Submissions Report

Infill Affordable Housing

138 Maroubra Road, Maroubra

SSD-81426710

S	11/12/24	JH							21_435	DA1.104	Y	
T	17/02/25	JH	RESIDENTIAL STORAGE NOTED / PLANNING AMENDMENTS CLOUDED									
U	15/05/25	JH										
V	18/09/25	JH										
W	16/02/26	ARH										
X	17/03/26	JH										
Y	19/05/26	ARH

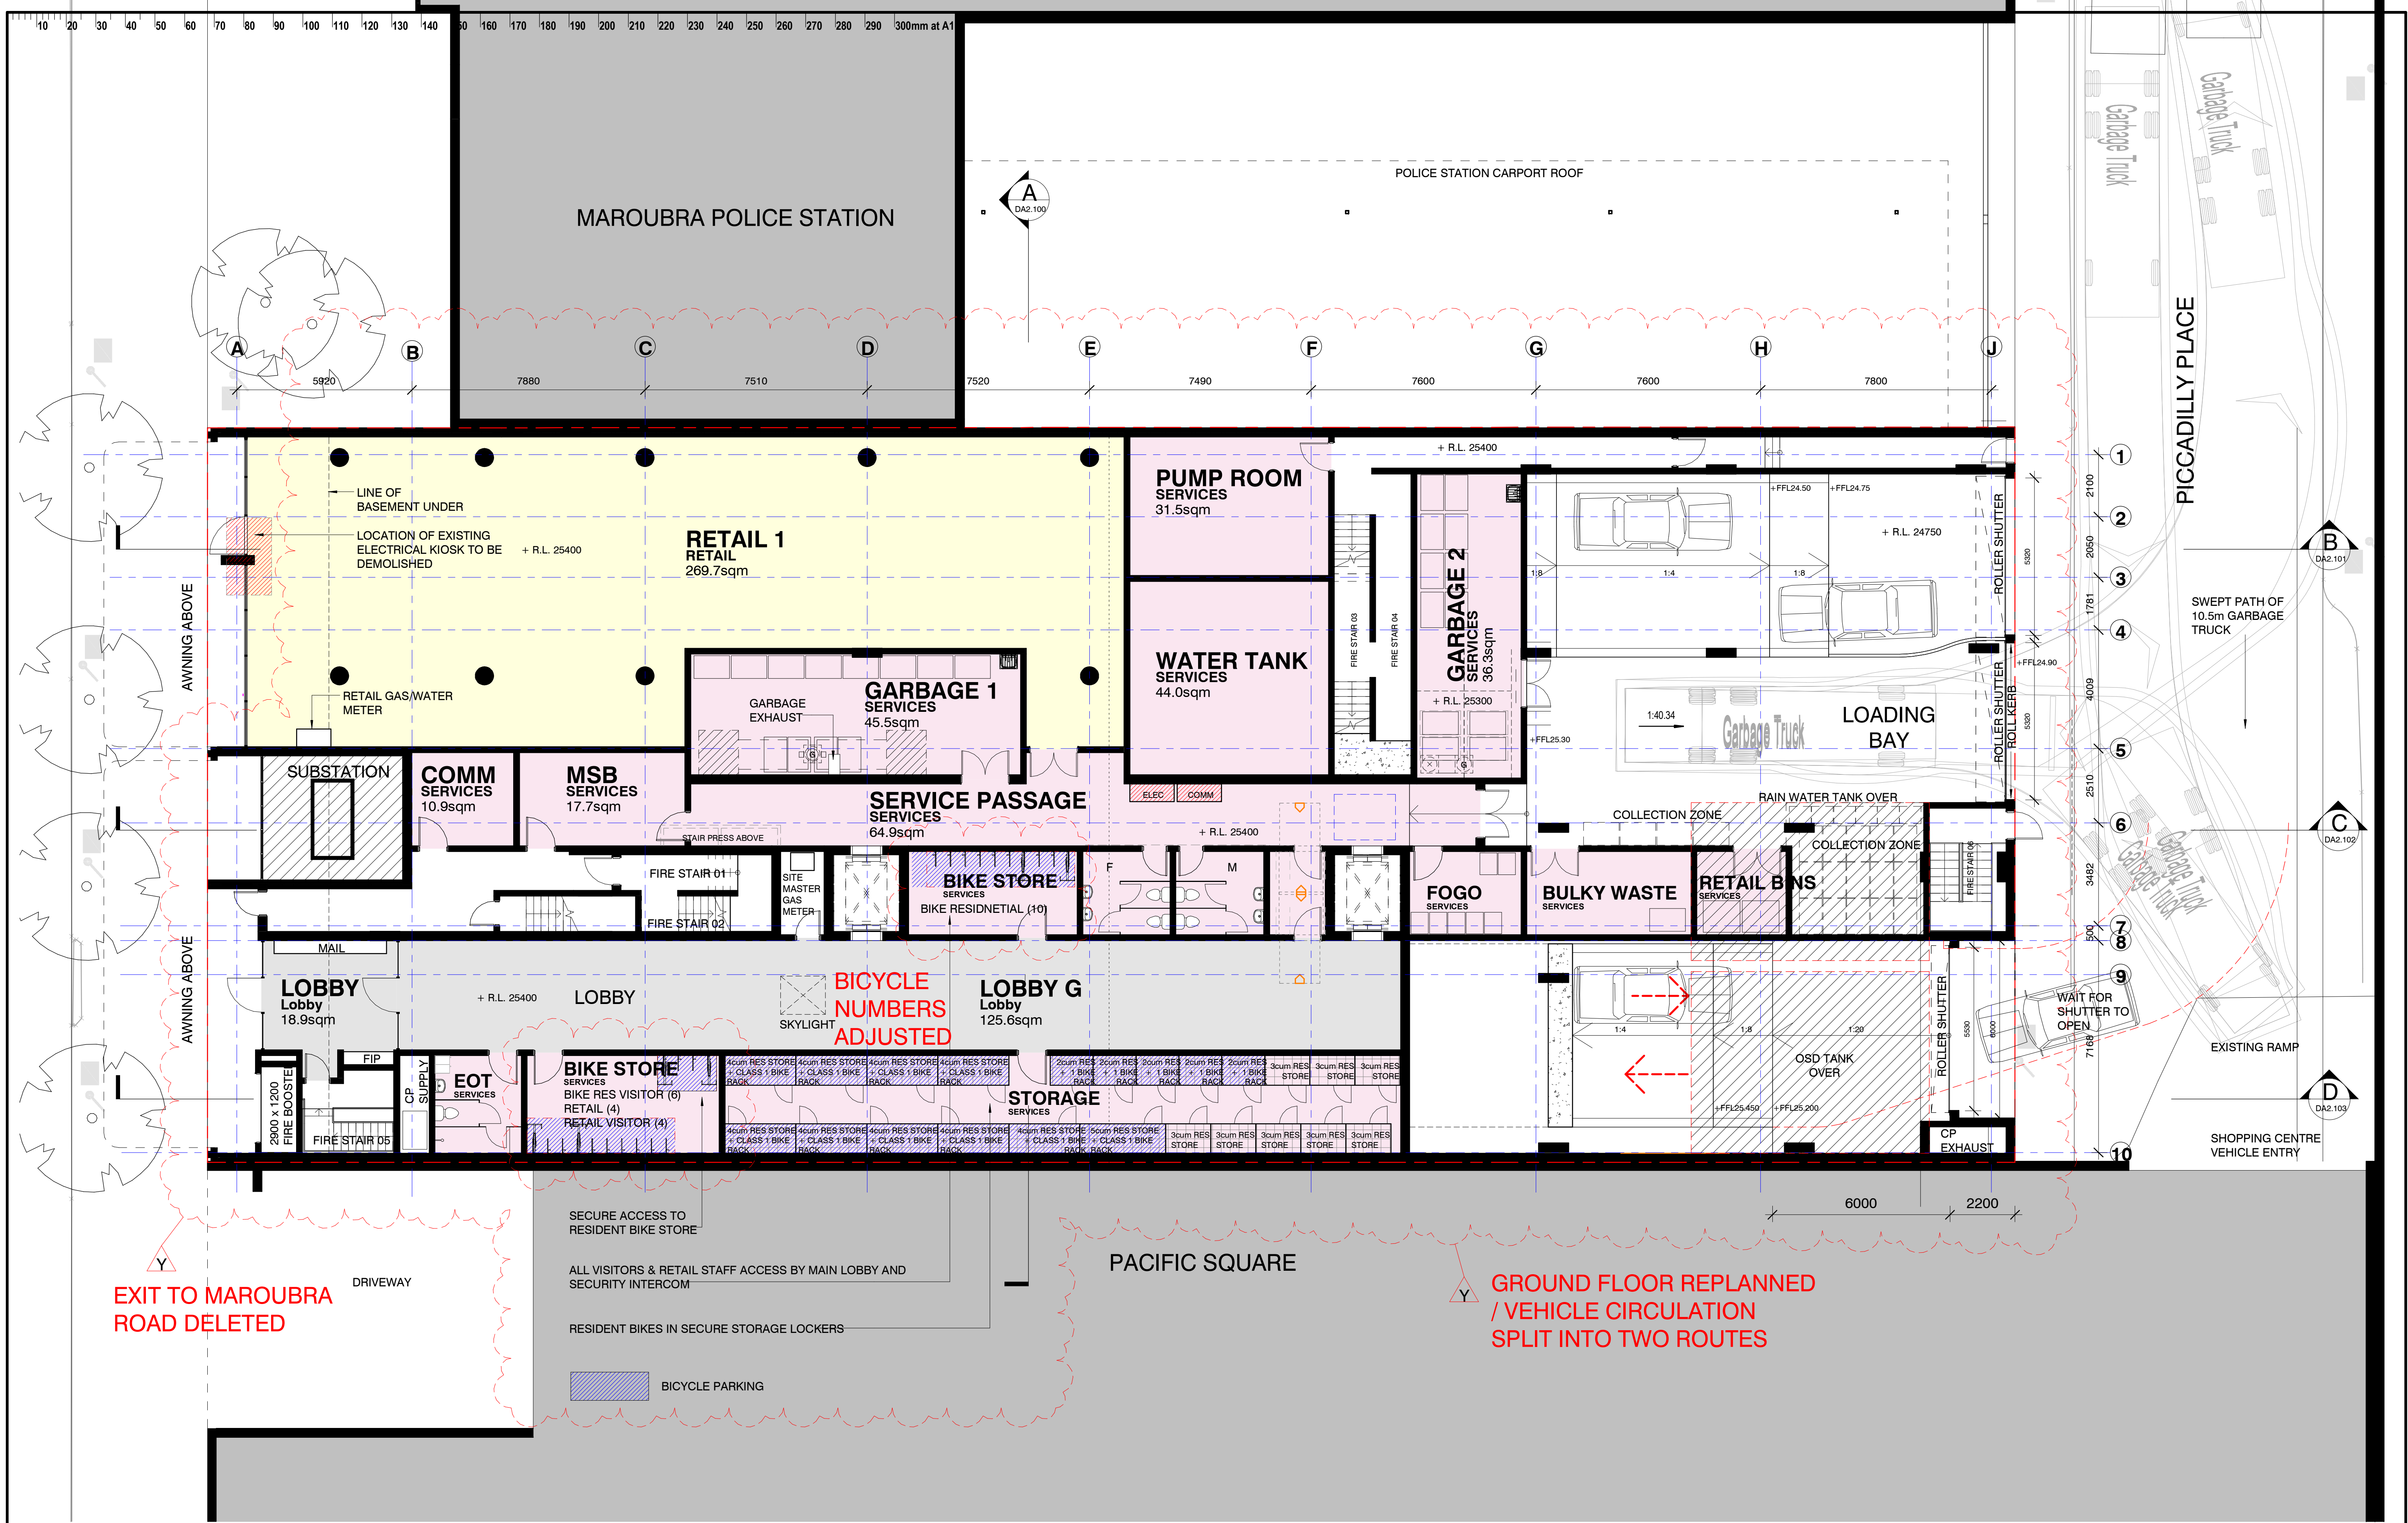
Item	Issue/ Comment	Proponent Response
Ground Floor Activation and Design Deficiencies		
	The increased width of the retail frontage and removal of vehicle egress to Maroubra Road is noted. However, Council does not accept the justification that the site's existing and surrounding inactive frontage reduces the need for active frontages. Relevant planning controls clearly require new development to deliver active street edges and improve upon current site conditions.	• The EIS and the Submissions and Amendments Report have identified the reasons as to why the whole of the Maroubra Road Frontage cannot be provided as active retail. • The Submissions and Amendments Report identifies that the existing condition along Maroubra Road is generally inactive (8% of the street frontage is active). The proposed development will replace a vacant building and will improve upon the current site conditions with regard to active frontages.

Overall, the layout prioritises servicing and internal circulation at the expense of active uses, reflecting a lack of design efficiency and integration. A fundamental re-planning is required to consolidate services, rationalise vertical circulation, and deliver continuous and flexible floorplates capable of accommodating retail at ground level and commercial uses at Level 1, consistent with the expectations of development within an E2 –Commercial Centre zone. Accordingly, Council finds that a comprehensive redesign is required to: • Prioritise and expand retail tenancies at ground level with a continuous and active street frontage; • Consolidate and relocate service, storage and plant areas to minimise their impact on active uses; • Provide a functional and adaptable commercial floor at Level 1; and • Deliver a legible, efficient and integrated internal layout consistent with the expectations of a mixed-use development within an E2 – Commercial Centre zone.	• The EIS and the Submissions and Amendments Report have identified the reasons as to why the whole of the Maroubra Road Frontage cannot be provided as active retail. • The provided internal configuration, including servicing, has been developed as a result of consultation with stakeholders over a long period of time. Specifically, the proposed layout has been informed by the following: – The substation must be provided to Maroubra Road as required by Ausgrid. – A single level of basement is proposed to minimise potential contamination from further excavation and in response to concerns raised by neighbours during the LEC process. – The design of the building must manage the constraints of the site including a narrow primary frontage with planning requirements such as active uses, end-of-trip facilities and staff amenities, services, storage, waste facilities. It is considered that there is no feasible alternative to the proposed building entrance from Maroubra Road provided all of these competing constraints. – There is no requirement to provide commercial floor at Level 1. The DCP does not apply to State significant development.

PROJECT No	DRAWING No	REVISION
21_435	DA1.103	X

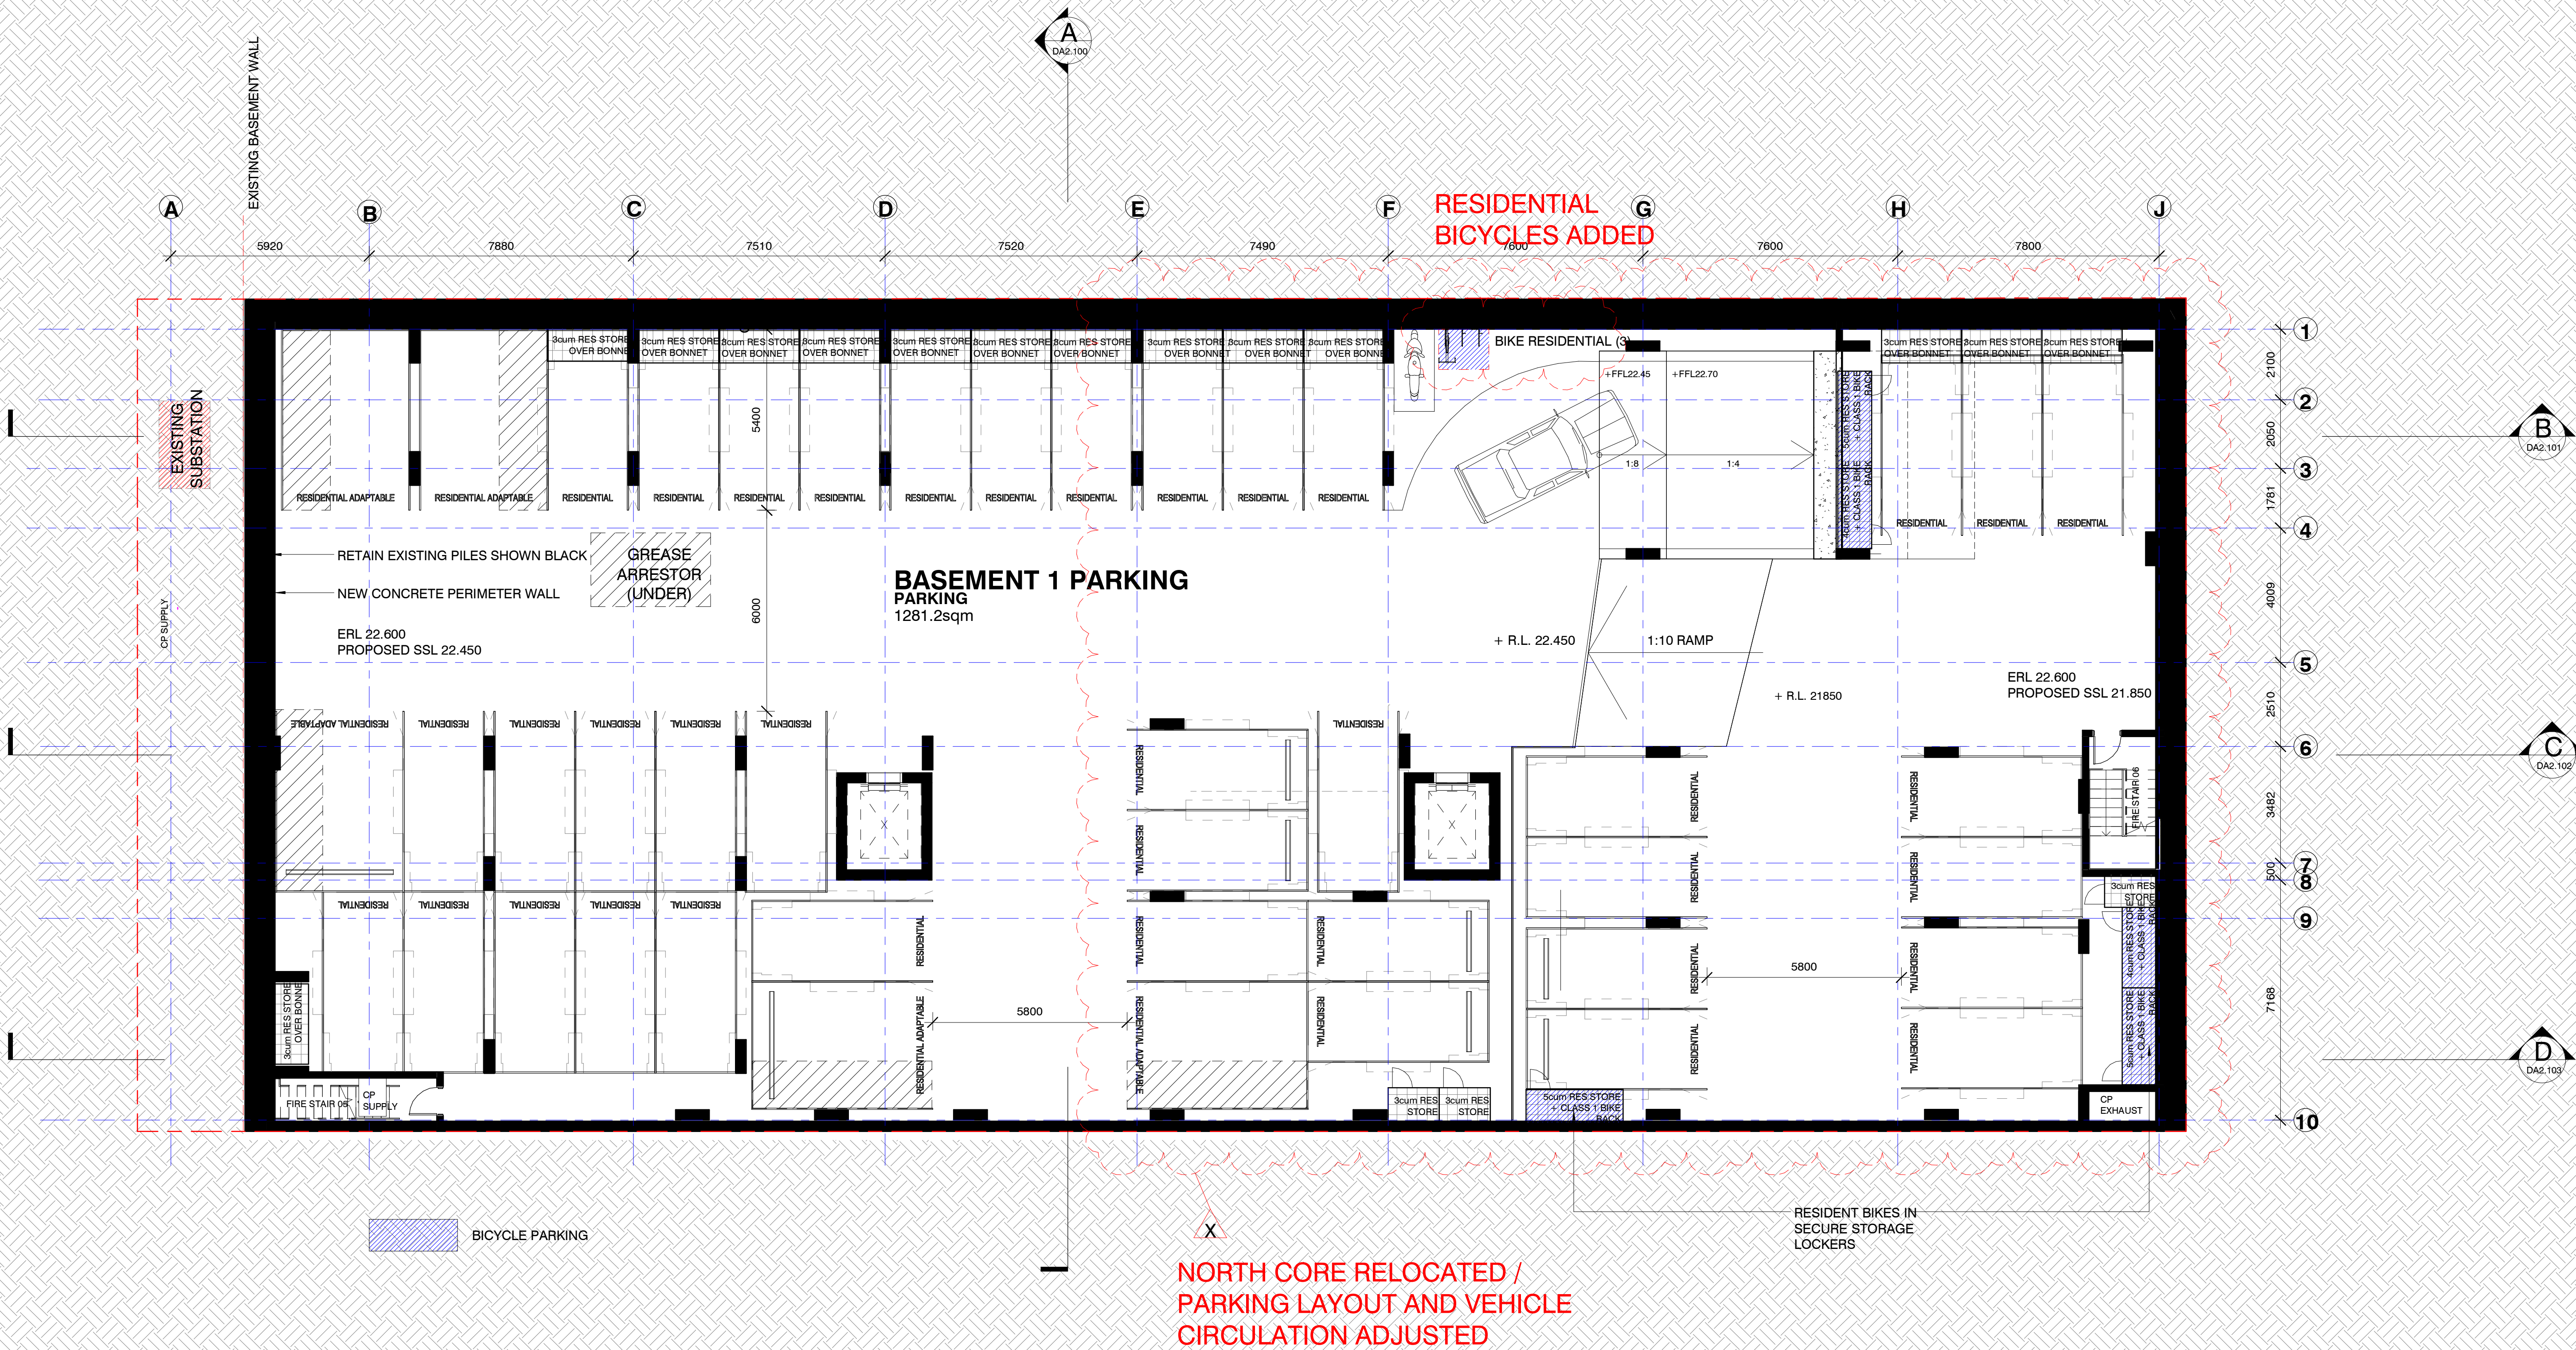
the viability and functionality of basement parking, including tandem arrangements;	The proposed car parking arrangements are supported by the Traffic Impact Assessment and are appropriate given the site-specific constraints and parking requirements for the proposal.
	the extent and impact of excavation; and	Excavation has been limited to a single level of basement car parking, 're-using' the existing single basement level. Only minor excavation is proposed to facilitate the single basement level.
	the visual impact of plant, substations and fire infrastructure on the streetscape.	- The EIS and the Submissions and Amendments Report have identified the reasons as to why certain plant, substations and fire infrastructure are required to be located to the Maroubra Road frontage. - The plant and infrastructure are located within the building footprint and do not result in any unreasonable visual impact.
